A585 Windy Harbour to Skippool Improvement Scheme

7.26 Responses to the ExA's Additional Written Questions and requests for information – ExQ3

**RESPONSES TO THE EXA'S ADDITIONAL WRITTEN QUESTIONS AND
REQUESTS FOR INFORMATION – EXQ3**

Version	Date	Status of Version
Rev 0	September 2019	Deadline 6a Submission

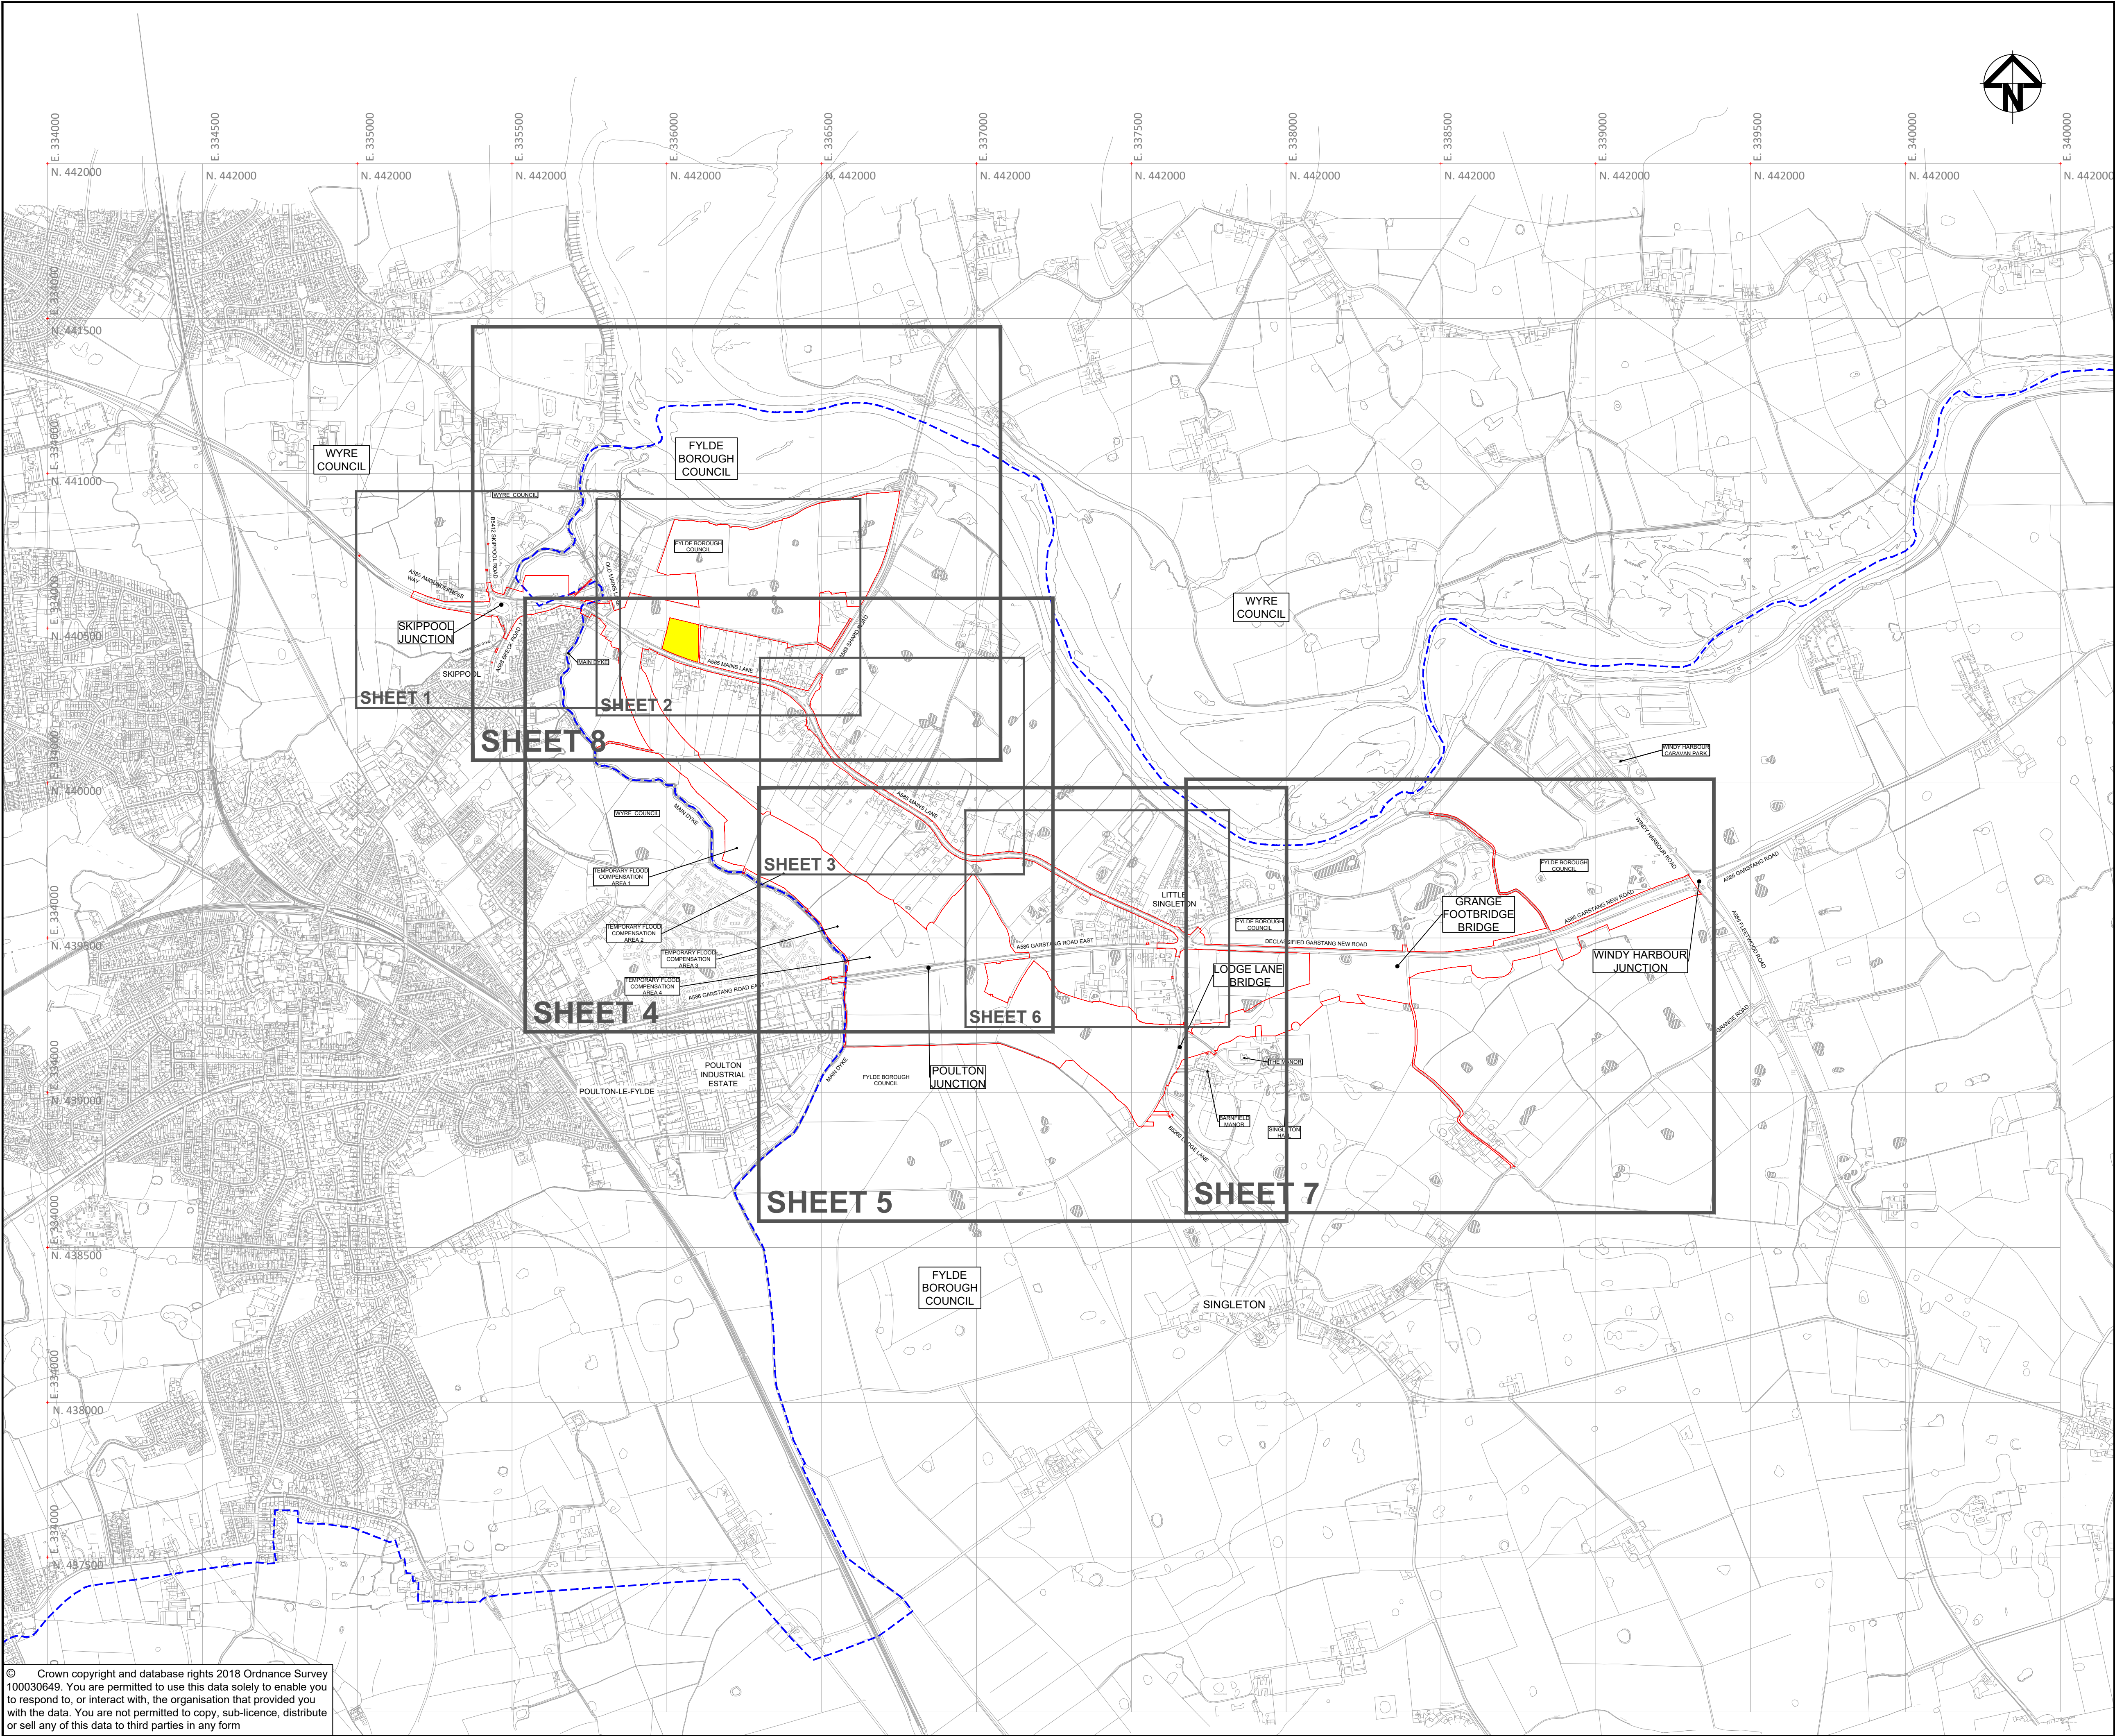
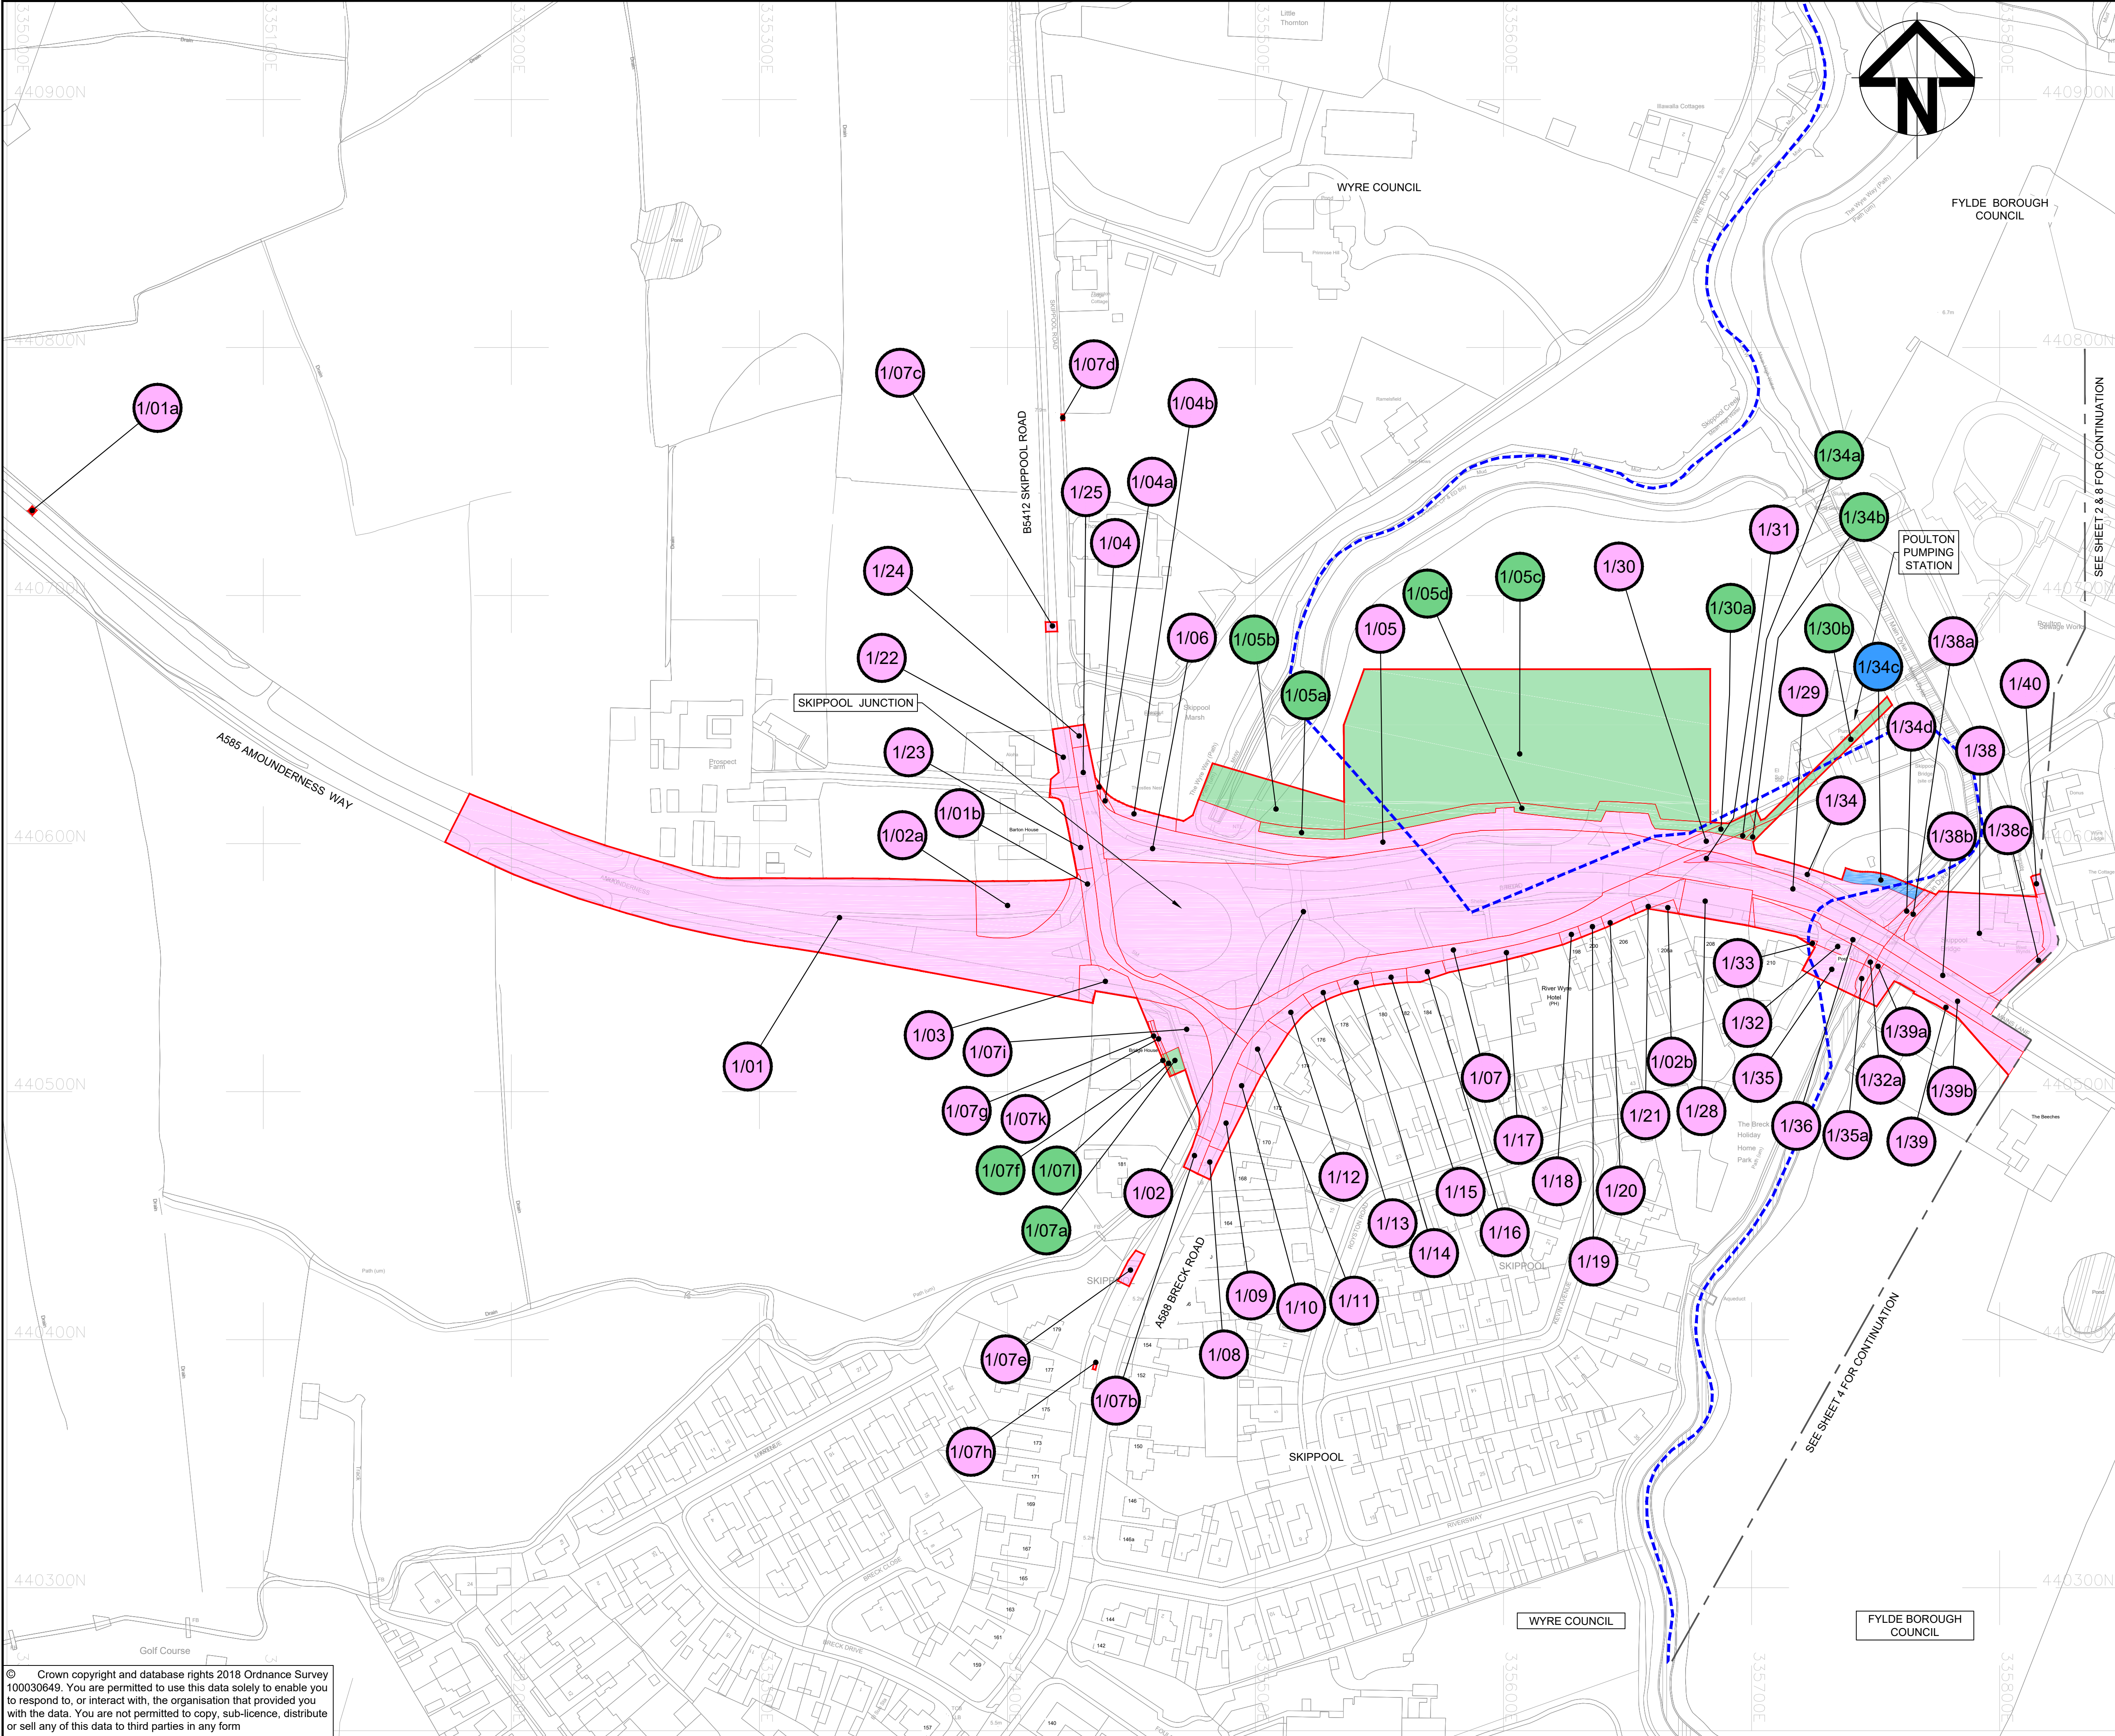
3.2.27	<p>Area not included in the DCO boundary</p> <p>The ExA still does not understand what the land coloured yellow on the plans is for, or why it is identified on the plans at all. The Applicant has not explained this in their response. If the land is not required for any works or required to be acquired permanently or used temporarily why is it highlighted on the plans? It is also confusing for it to have a red boundary if the intention is for this area to be outside of the draft order limits which are defined by a red boundary. Please explain the reasons for the above?</p>	<p>The land coloured yellow is not part of the Development Consent Order and therefore is not required permanently or temporarily to deliver the scheme. [This is explained in the key to the drawings.]</p> <p>This approach is an accepted industry standard method of identifying land which is enclosed by the red lines of the order limits but is not required for the scheme. Other applications have used a similar approach (such as A19 Testos). Colouring the land yellow helps the reader of the plans to easily identify that the land is outside the red lines, something which cannot always be readily seen where there are inner and outer red lines.</p>
